## Application for a Non-Material Amendment Following a Grant of Planning Permission

Demolition of existing workshop and erection of swimming pool building and 1no. holiday let unit

22/0995/FUL

The length of the proposed pool building is to be increased by 2m.

drawing title
SWIMMING POOL BUILDING LAYOUT & ELEVATIONS

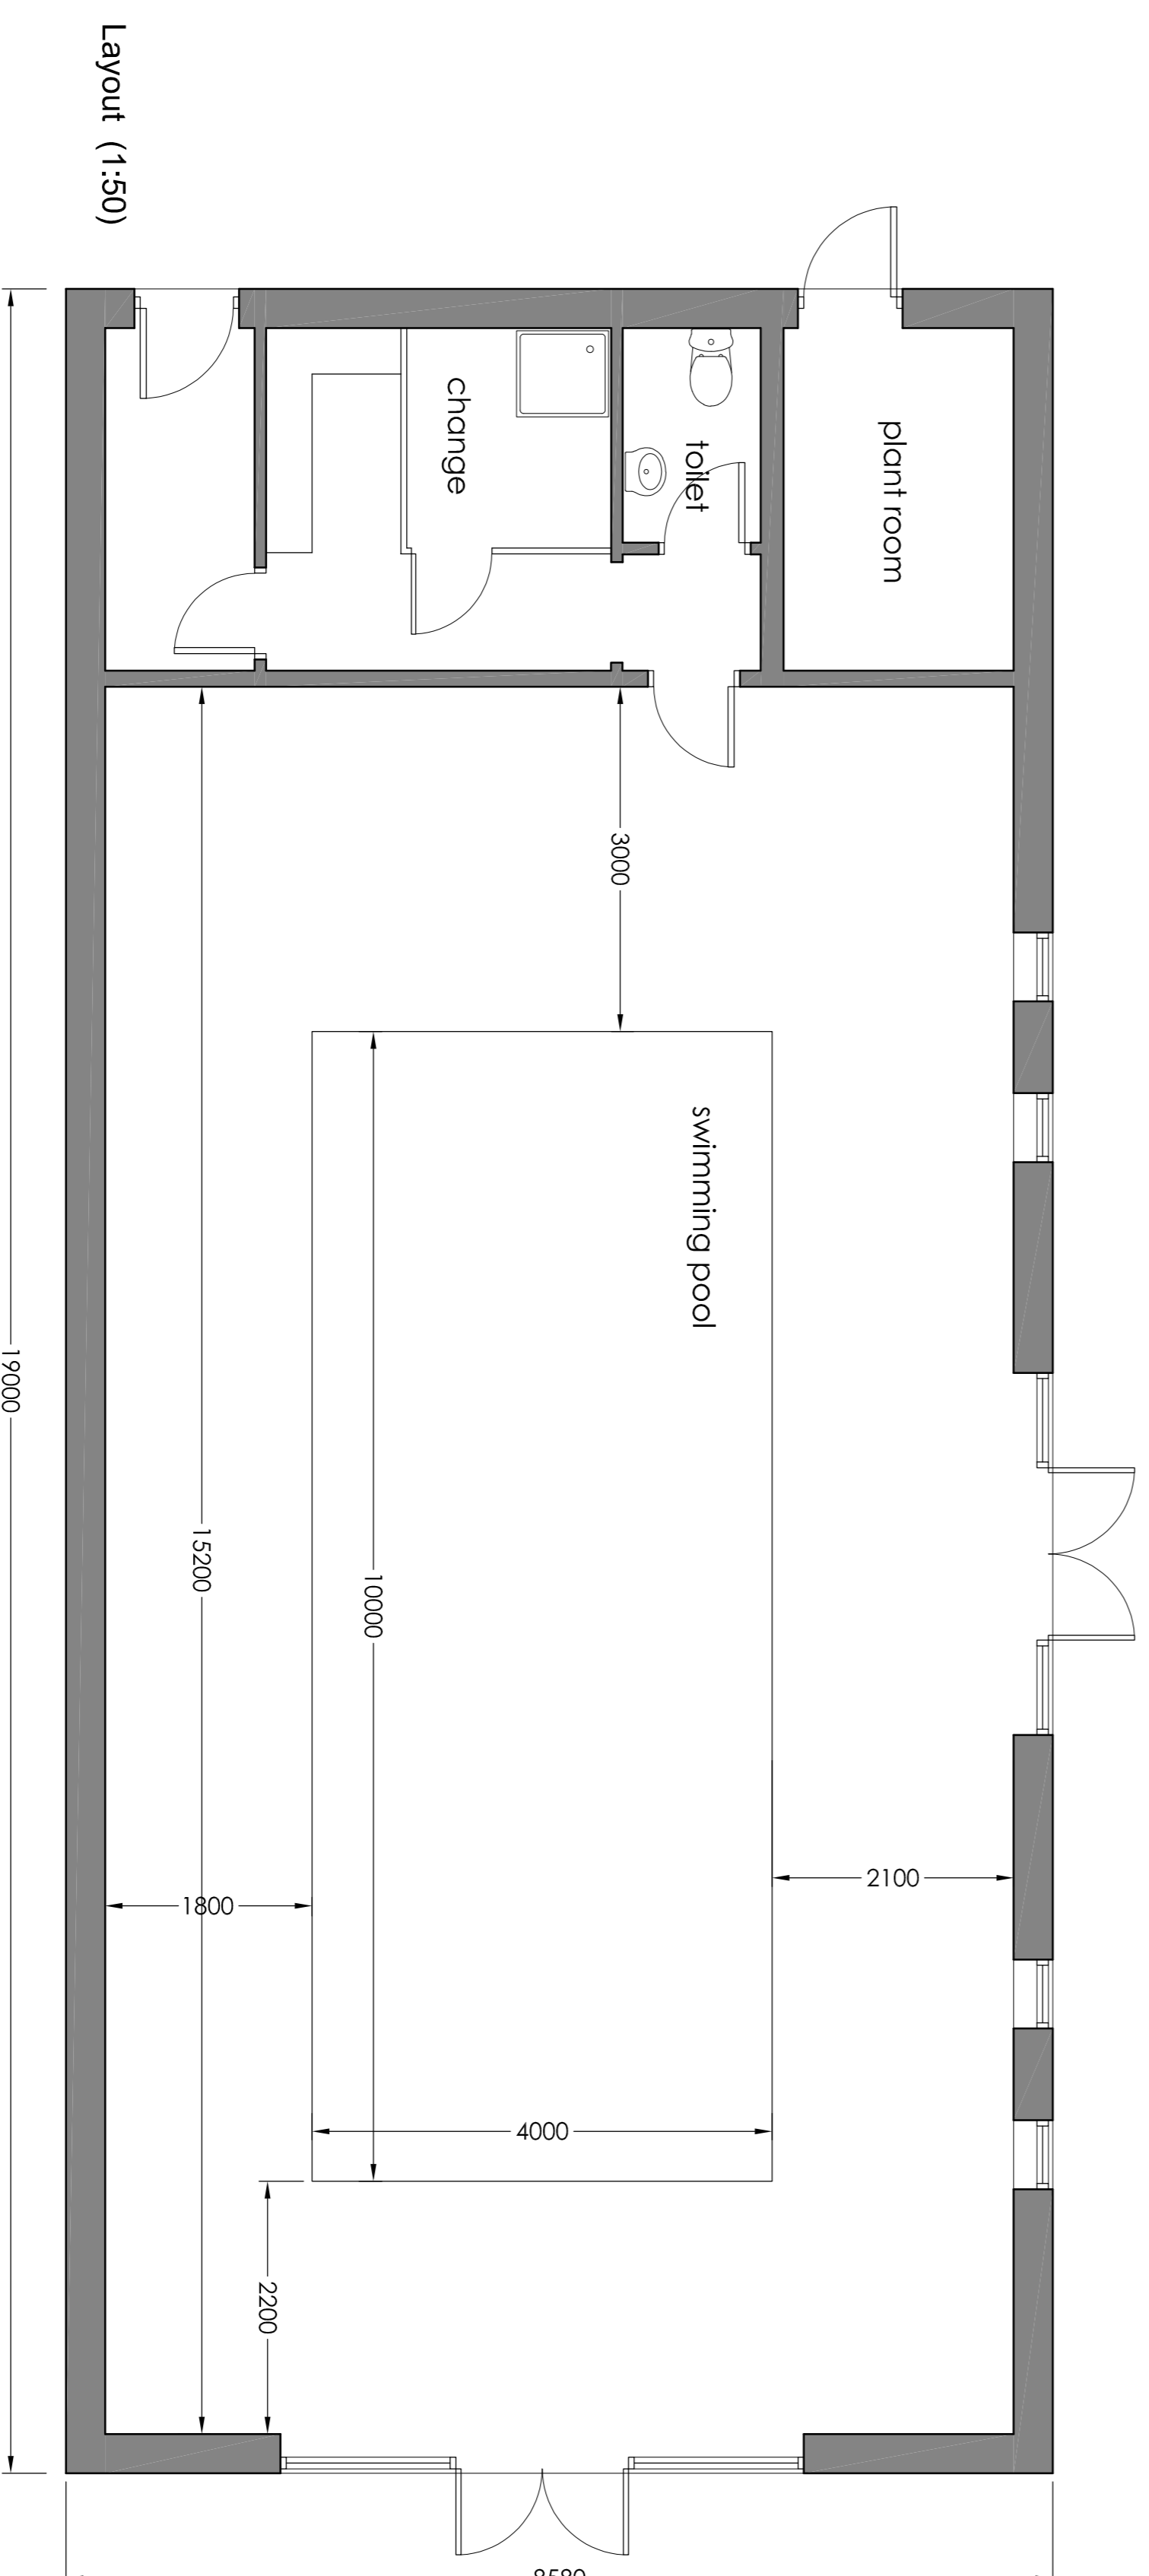
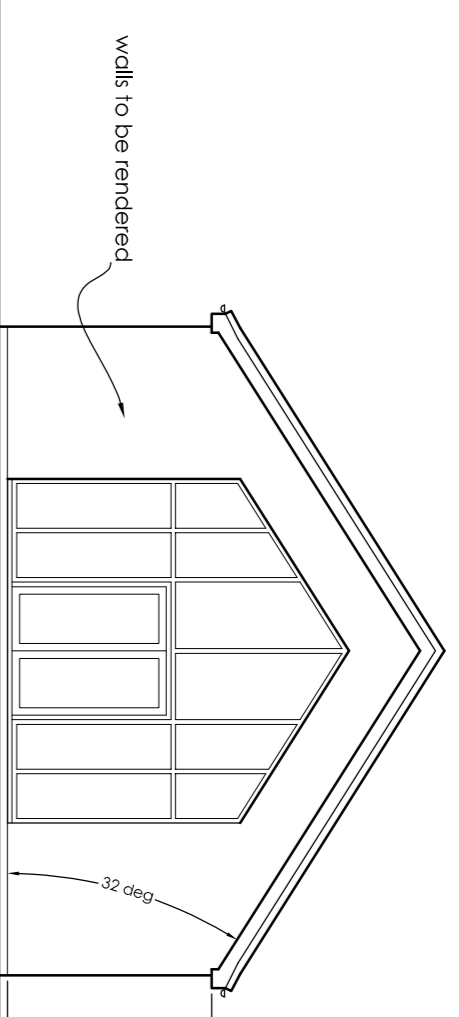
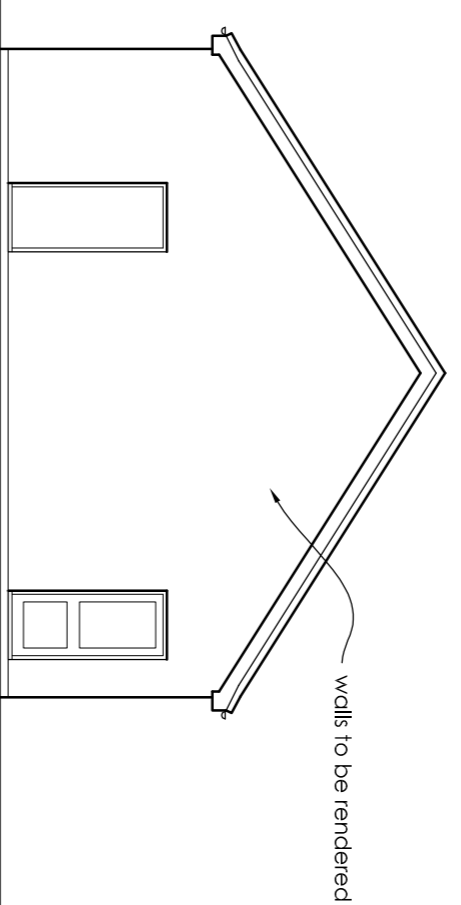
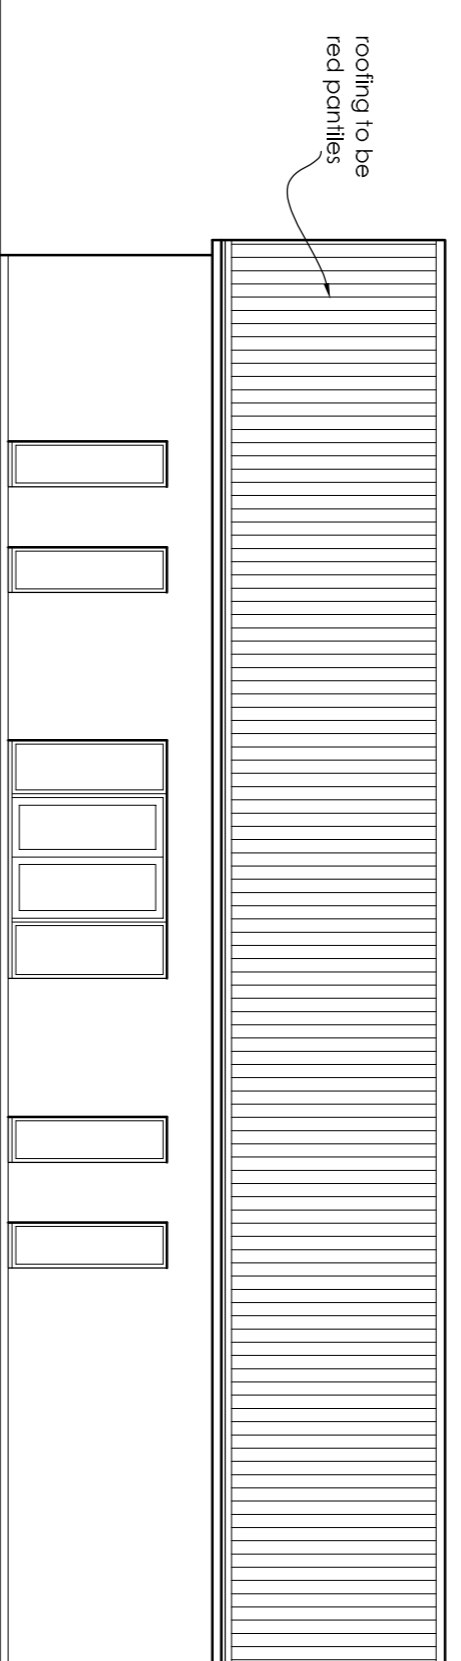
This makes the new building the same length as the existing workshop and allows an existing wall to be retained - preventing major works being required to the existing adjoining house.
